# **A46 Newark Bypass**

**Scheme Number: TR010065**

## **Statement of Common Ground with Newark and Sherwood District Council 'NSDC'**

**Statement of Common Ground with  
Newark And Sherwood District Council**

- NOTES**
- THIS DRAWING IS TO BE READ IN CONJUNCTION WITH THE DRAFT DEVELOPMENT CONSENT ORDER AND ACCOMPANYING APPLICATION DOCUMENTATION. (TR010065/APP/3.1).

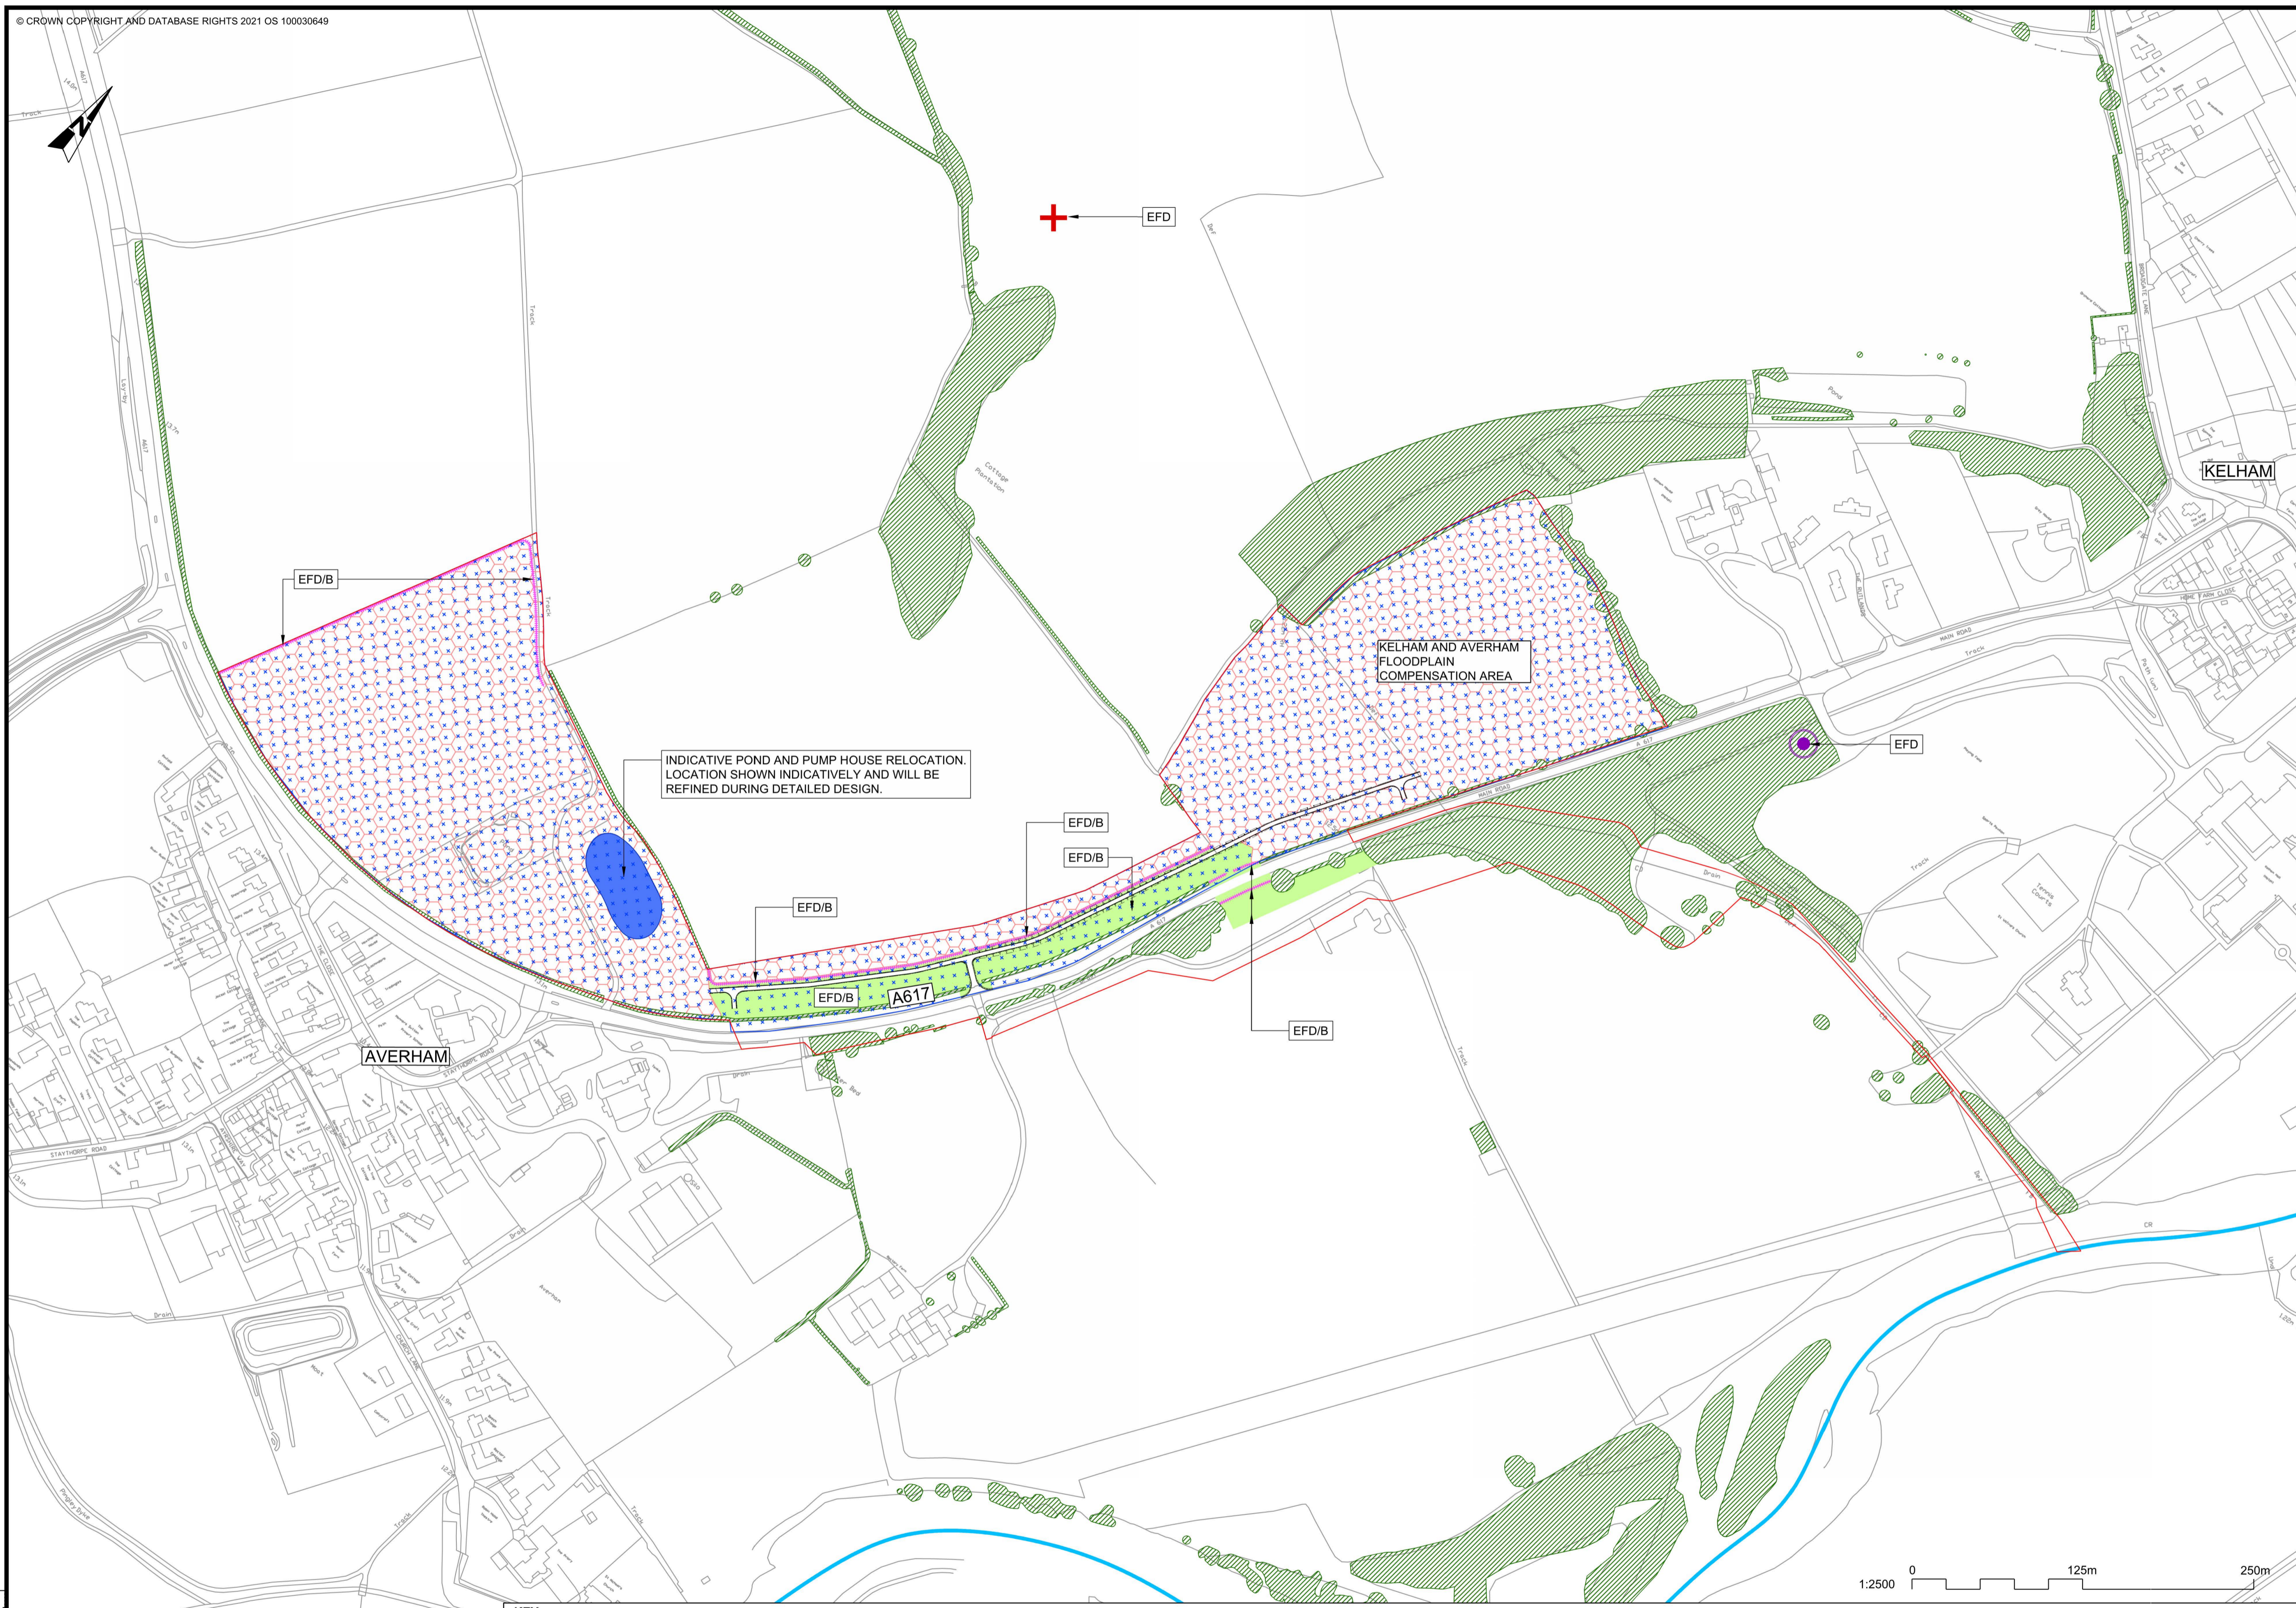
Issue No.	Issue	Document Reference	Newark and Sherwood District Council's Position	The Applicants Position	Status	Date status confirmed
12.	Design (including justification for any flexibility being sought)	Chapter 2 The Scheme of the Environmental Statement [APP-046] 6.2 Environmental Statement - Figure 2.3 Environmental Masterplan [AS-026]	<b>Cattle Market flyover</b> On the fly-through video the structure of the elevated over-pass at the Cattle Market junction appears as a stark and imposing concrete structure. This may be in part due to the animation which depicts it as being very bright in colour and therefore standing out vividly. The Council would want to understand proposals to ensure the visible impact of the final structure is minimised and/or mitigated as far as practicable.	Consideration has been given to the aesthetic finish of the structure during the design development to help to reduce the visual prominence of the structure and to reflect finishes on existing structures such as that of Smeaton's Arches just to the north of the new junction. Further details of these can be found within Chapter 2 The Scheme of the Environmental Statement [APP-046] and 6.2 Environmental Statement - Figure 2.3 Environmental Masterplan [AS-026]. Planting of trees and shrubs has also been considered and incorporated wherever feasible to help break up the visual mass of the structure, with planting softening the built form and aiding screening over time, particularly from properties such as those in Sandhills Park affording near distance views. The assessment of landscape and visual effects and associated design and mitigation measures are described in 6.2 Environmental Statement - Figure 2.3 Environmental Masterplan [AS-026] and presented in 6.2 Environmental Statement - Figure 2.3 Environmental Masterplan [APP-026]. Part of the Detailed Design process will be to define the finish of the retaining walls forming the Cattle Market Flyover. This will be a masonry type façade and not a bare concrete finish.	Under Discussion	16/10/2024
